Consultation Response from KC Strategic Housing

2024/93474 at land at, 35, St John's Rd, Birkby, Huddersfield, HD1 5DX

Change of use from vacant industrial unit to 21 flats / maisonettes including partial demolition and new build

Date Responded:01/09/2025

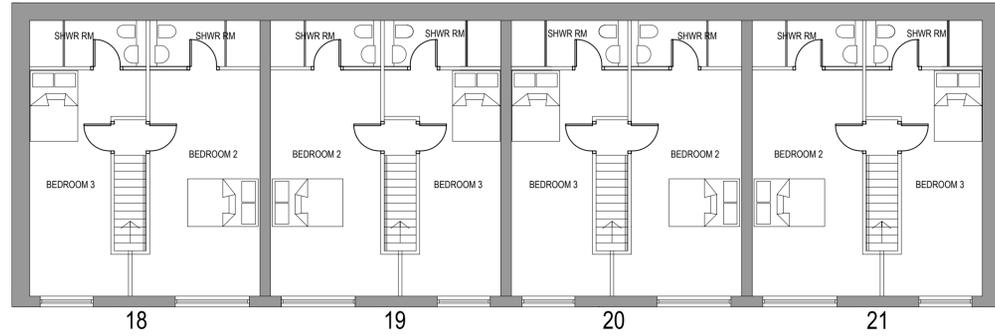
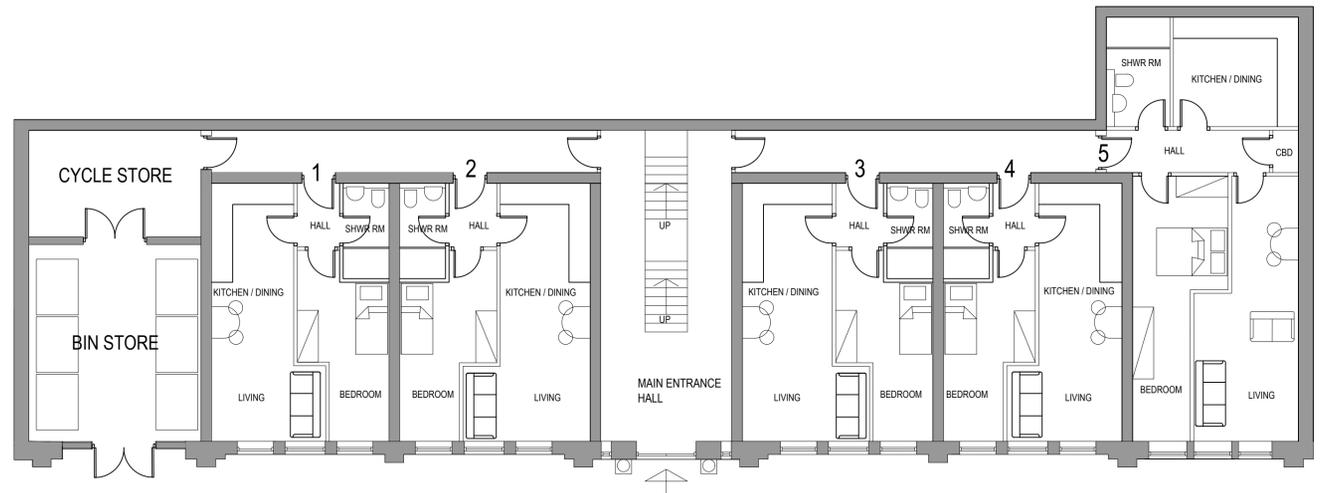
A new site block plan shows the proposed development to be comprised of 21 flats / maisonettes (17 x 1beds and 4 x 2beds).

The affordable homes are proposed as follows: 3 x 1bed units and 2 x 2bed units.

At minimum, 20% of the overall units - 4 units, would be sought for as affordable housing. Providing more than the minimum 20% affordable units, as proposed, is welcomed.

Type: There's demand for affordable 1-2 bedroom homes in particular in the area, as well as affordable 3+ bedroom homes. As the development is a flat building with some maisonettes, rather than houses, and there is a significant need for affordable 1-2 beds, provision of 1beds and 2beds is acceptable. If there is any capacity for providing any 3beds as part of the housing mix for the development, this should be considered by the applicant.
